From: Harwood, Paul [REDACTED]
Sent: 11 April 2017 15:21
To: Planning.Responses
Cc: David Easton
Subject: FW: Land west of Brook Lane and South of A259 Angmering BN16 3JL.
Importance: High

Site: Land west of Brook Lane and South of A259 Angmering BN16 3JL.

Planning Application No: A/44/17/OUT

Highways England Ref: HAMIS 77357

Figure 6.2: Care Home Trip Distribution

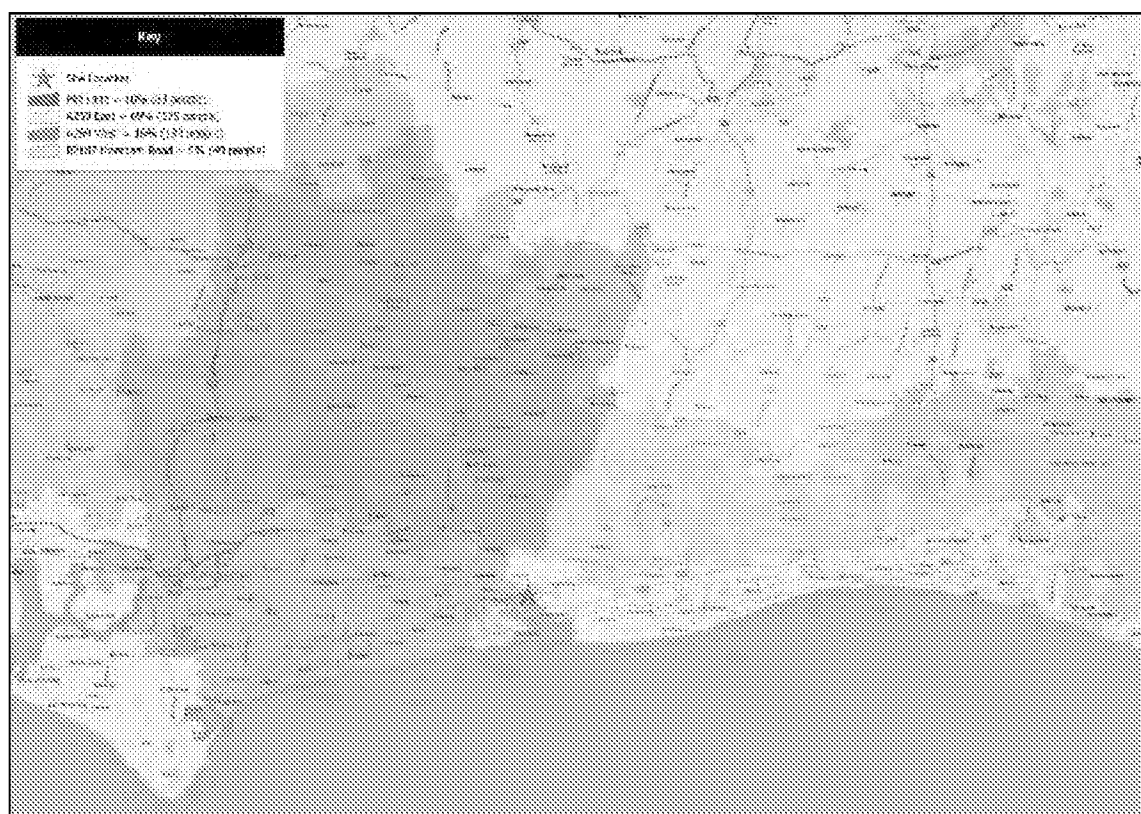
3. The trip distribution is not 100% clear - the site is directly accessed from the A259, yet the distribution also includes Horsham Road and Mill Lane (presumably these are accessed after the A259?) and thus it would be useful if a separate distribution and traffic flow diagrams were provided for development traffic only. Similarly, the distribution/traffic flows are not considered beyond the closest 2 roundabouts and thus it is not clear how many trips are expected to end up at the A27.
